WEST SUSSEX COUNTY COUNCIL CONSULTATION

TO:	Arun District Council FAO: Mr S Davis
FROM:	WSSC – Highways Authority
DATE:	24 July 2026
LOCATION:	Land At Freeman Close Walberton BN18 0AE
SUBJECT:	WA/46/26/PL Change of use of and conversion of existing buildings and land to form 25 no. dwellings (within existing footprints) with associated hard and soft landscaping, parking, car ports, play areas, and works. This application is a Departure from the Development Plan, also lies within the parish of Barnham and is in CIL Zone 3 and is CIL Liable as new dwellings.
DATE OF SITE VISIT:	n/a
RECOMMENDATION:	No Objection

PROPOSED SITE PLAN

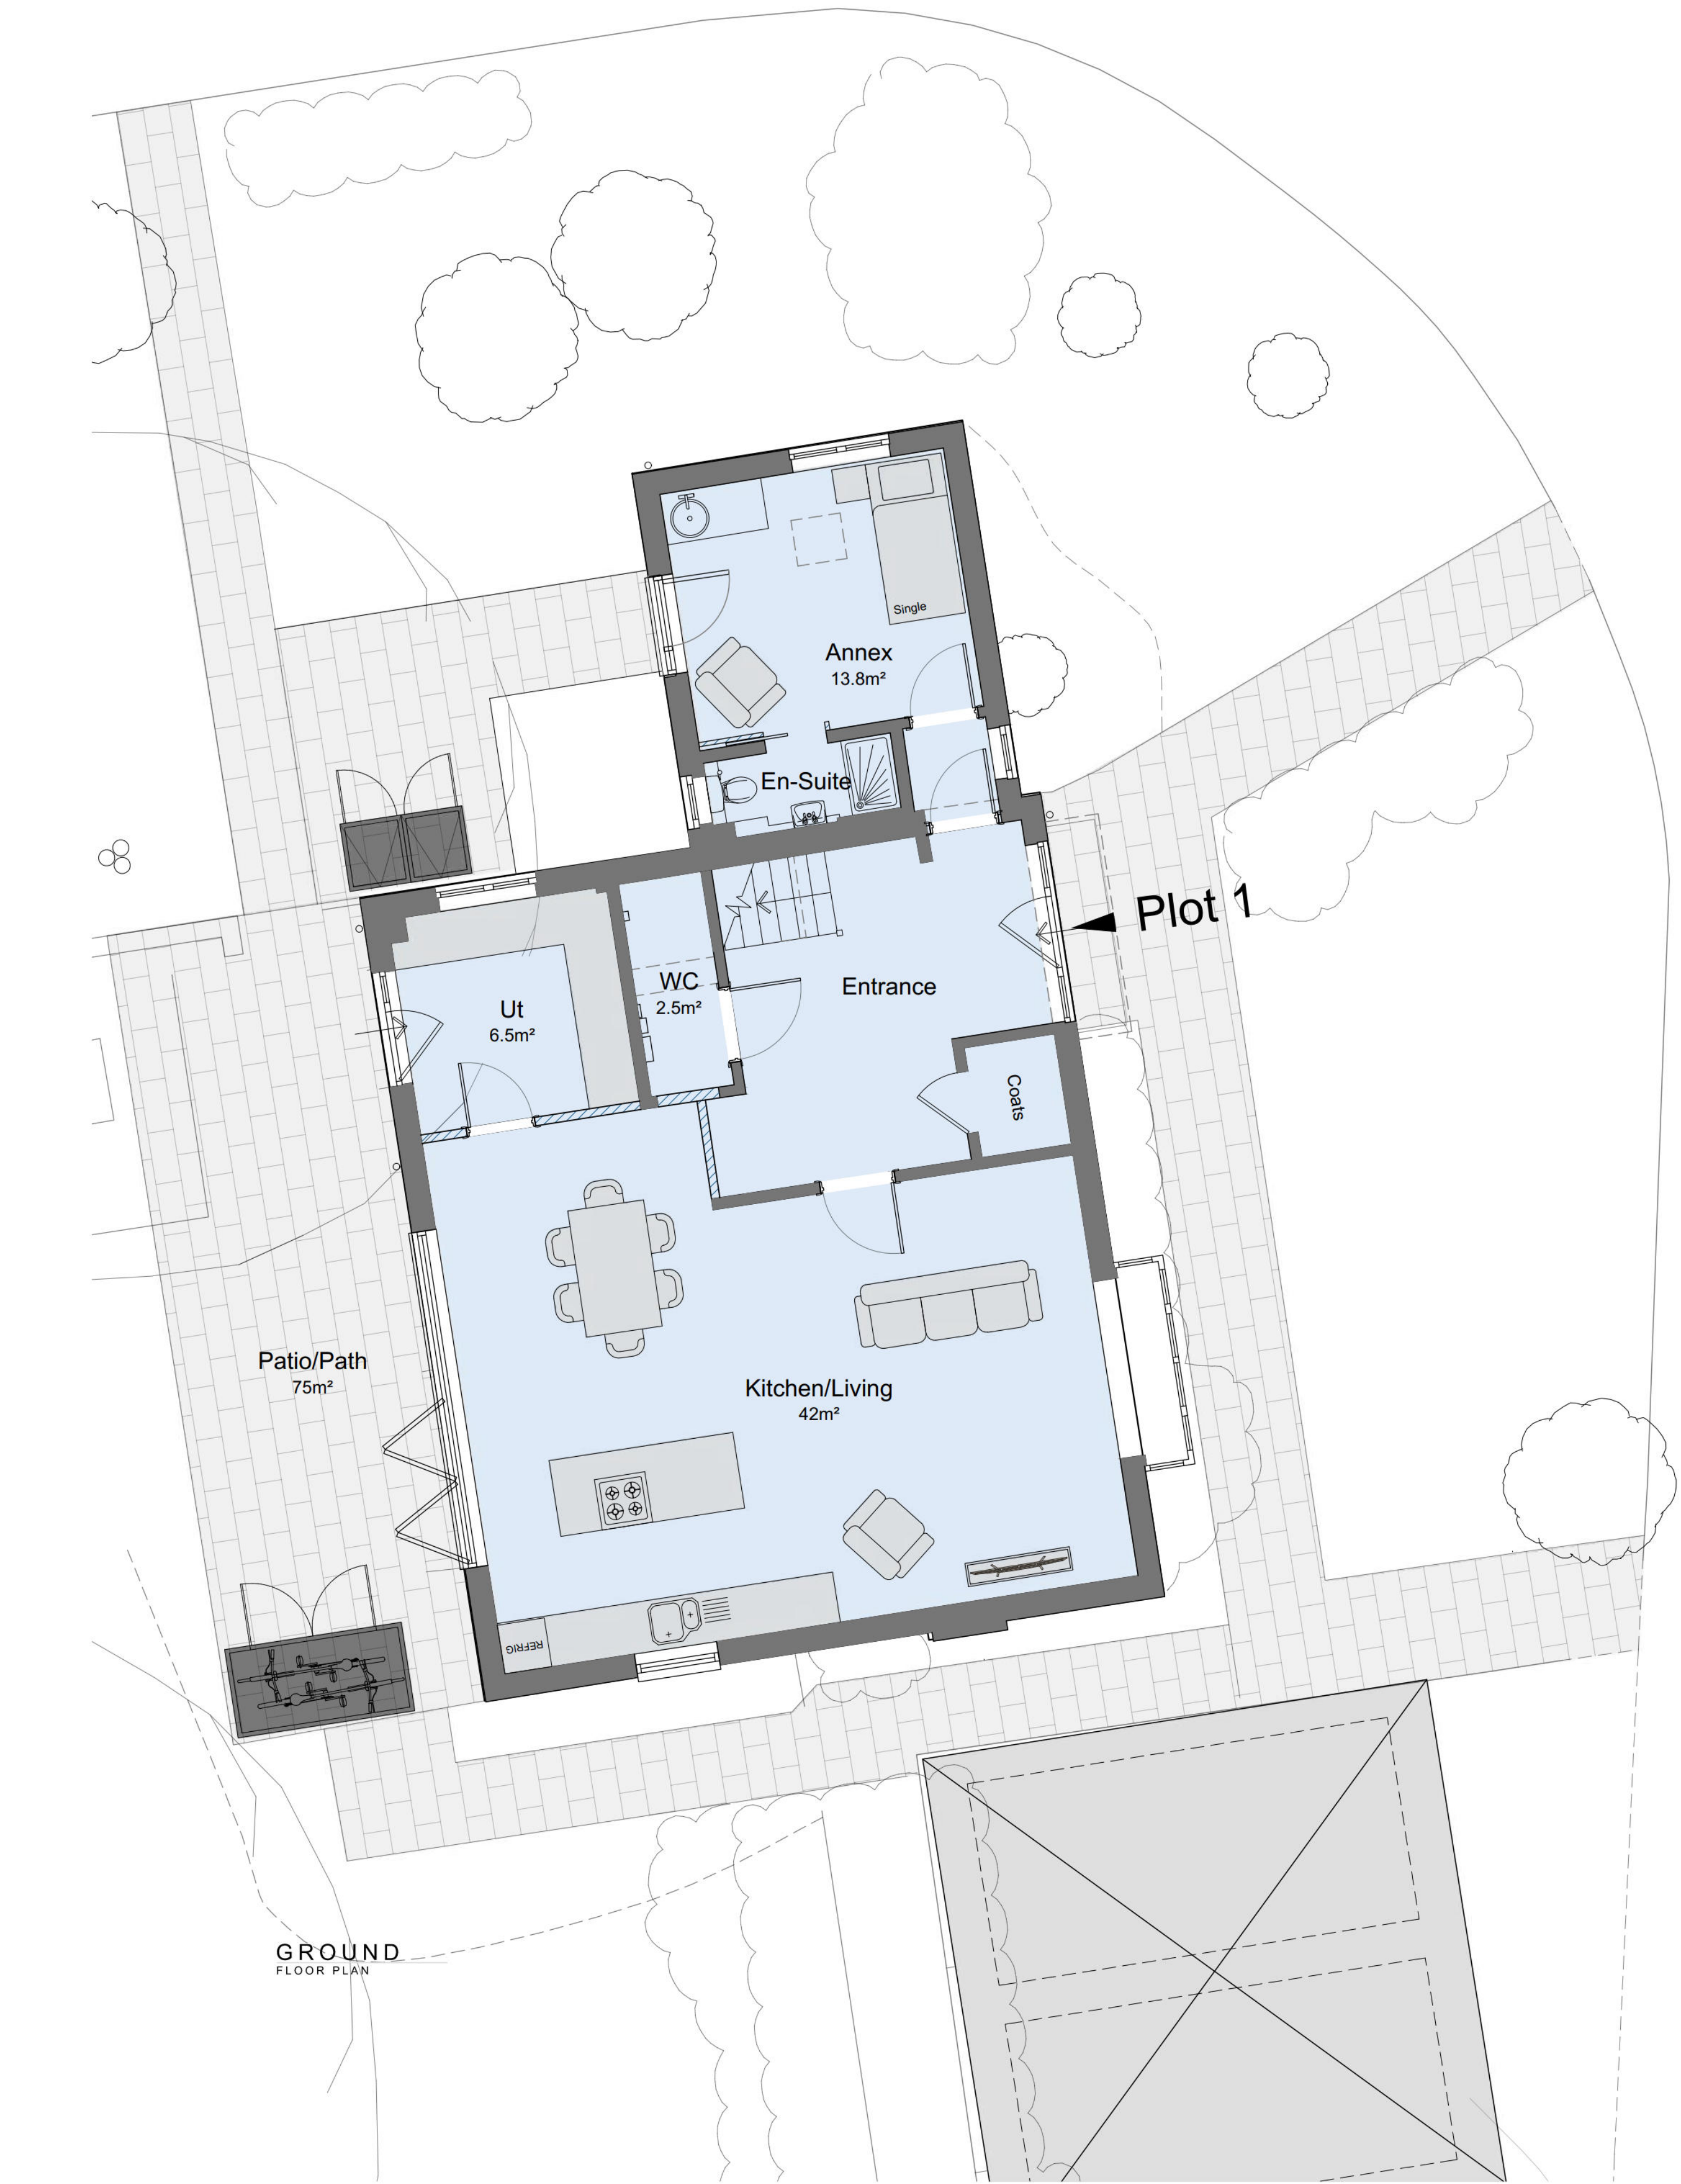
The site provides a footway on the right hand of the development all the way to the access. As Eastergate Lane doesn't have any footways there are none to link into, however the footway would allow pedestrians or cyclist to use the footway up to this point where it meets the carriageway.

A dropped kerb without tactile paving, as it does not cross over to anything should be provided here. There is also a footpath that intersects with the footway providing access to the open grass area at the front of the development.

WSCC note that parts of the internal layout have not considered the impact on people with mobility or visual issues which may cause problems if they were to try to walk within the site.

Internally the footway could wrap around the turning area dropping a pedestrian into the shared surface block paved roads either side. However, whilst this would provide a pedestrian with limited eyesight or mobility issues a safer and clearer experience It is also noticed that access to the other outdoor play area is directly opposite this footway so there is a natural desire line, to cross here to reach the play space.
